Rezoning Transportation Analysis

Petition Number: 2021-119

Date	Description
09-23-2021	First Review (KP)

SHEET NUMBER
RZ-1

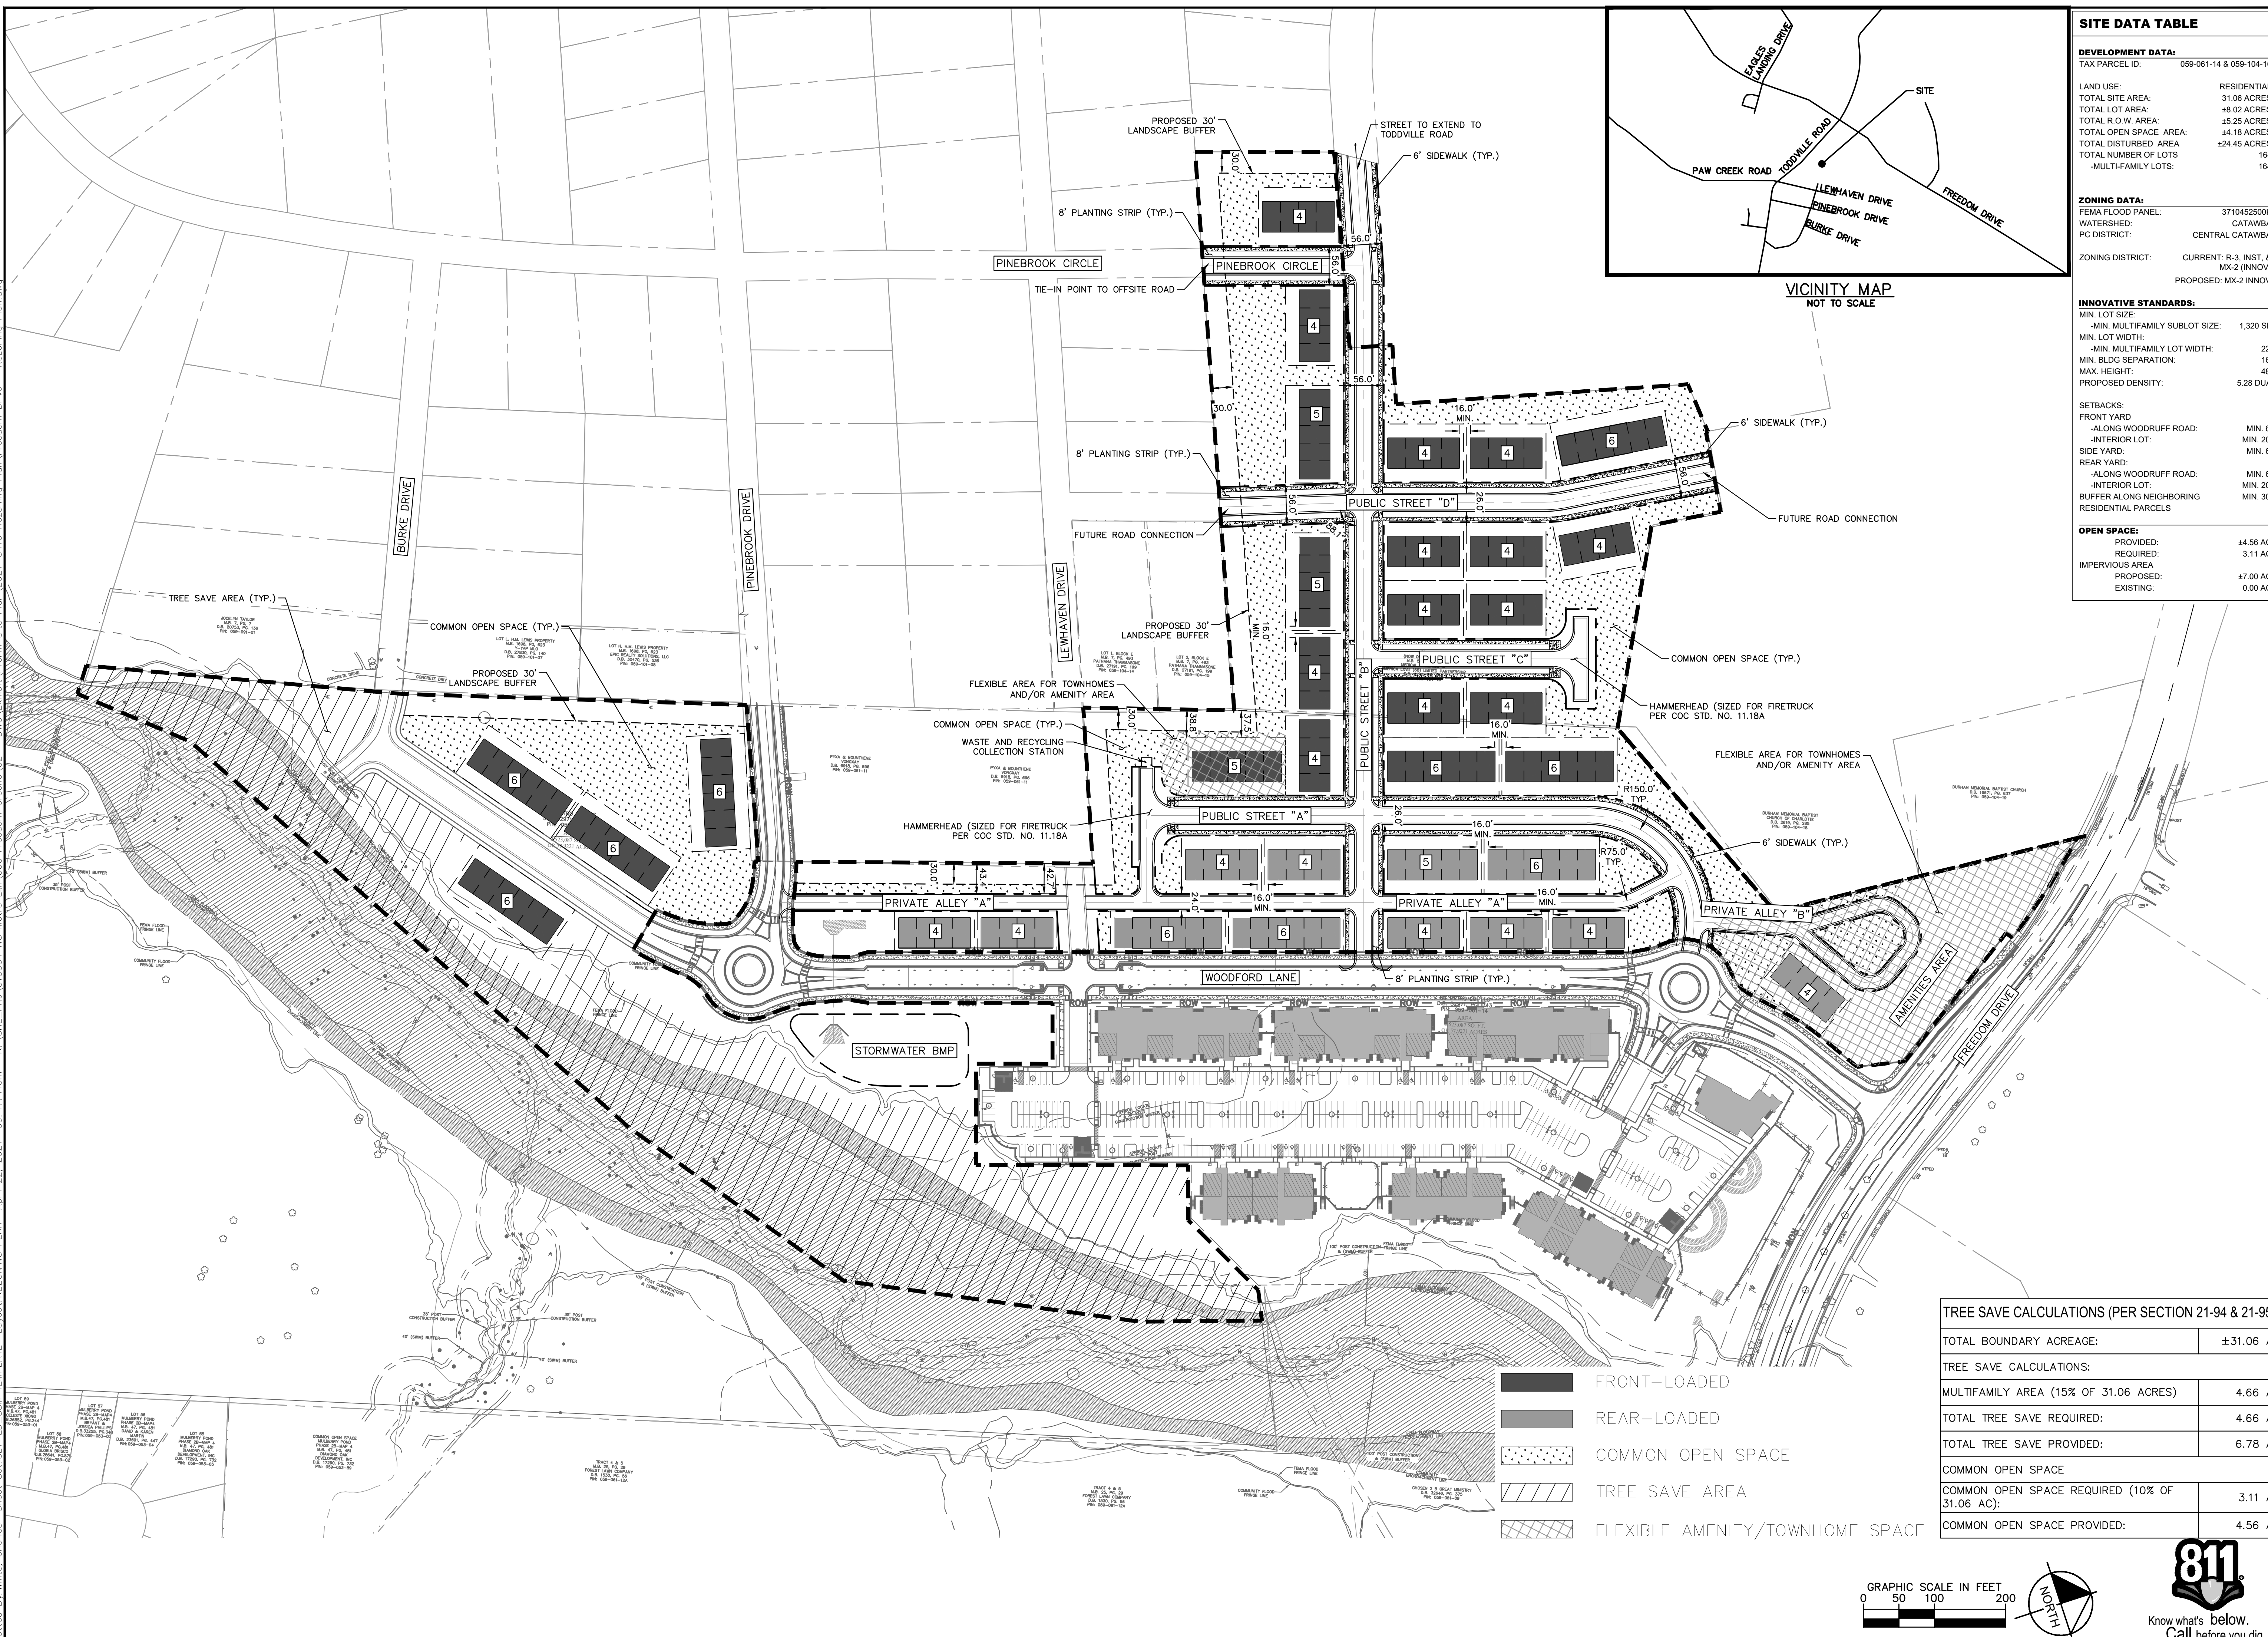
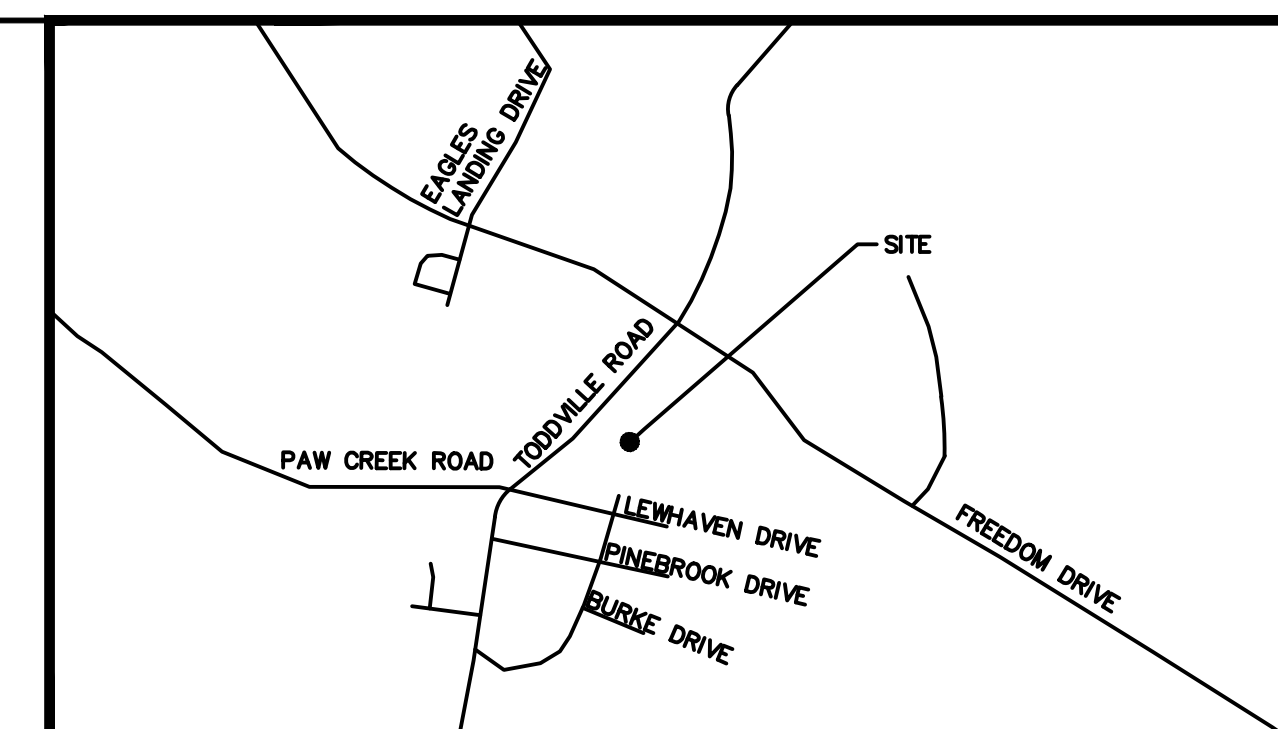
2. Revise site plan and conditional note(s) by classifying each proposed public street in accordance with the USDG Street Cross Sections depicted in the Charlotte Land Development Standards Manual.

3. Revise site plan and conditional note(s) by committing to connecting proposed Public Street B to existing Leaf Tree Drive. This connection will be subject to CDOT approval during permitting.

4. Revise site plan and conditional note(s) by committing to extend the sidewalk along proposed Public Street B, and existing Leaf Tree Drive, and connect to the existing sidewalk at the intersection of Toddville Road and Leaf Tree Drive. Additionally, the appropriate PROWAG and ADA curb ramps will be constructed at the intersection of Toddville Road and Leaf Tree Drive.

5. Revise site plan and conditional note(s) by committing to coordinating with NCDOT, during permitting, to construct a westbound left-turn lane, with 100-feet of storage and appropriate bay taper length, on Freedom Drive to turn onto Woodford Lane. The appropriate storage and bay taper lengths will be subject to NCDOT approval.

- 6. Revise the site plan by changing proposed Public Street A and Public Street C to private streets. Additionally, please label and dimension the back-of-curb locations and the planting strip(s) and sidewalk(s).

7. Revise the site plan by including the Accela Project Numbers associated with each previously permitted and approved development(s) along Woodford Lane.
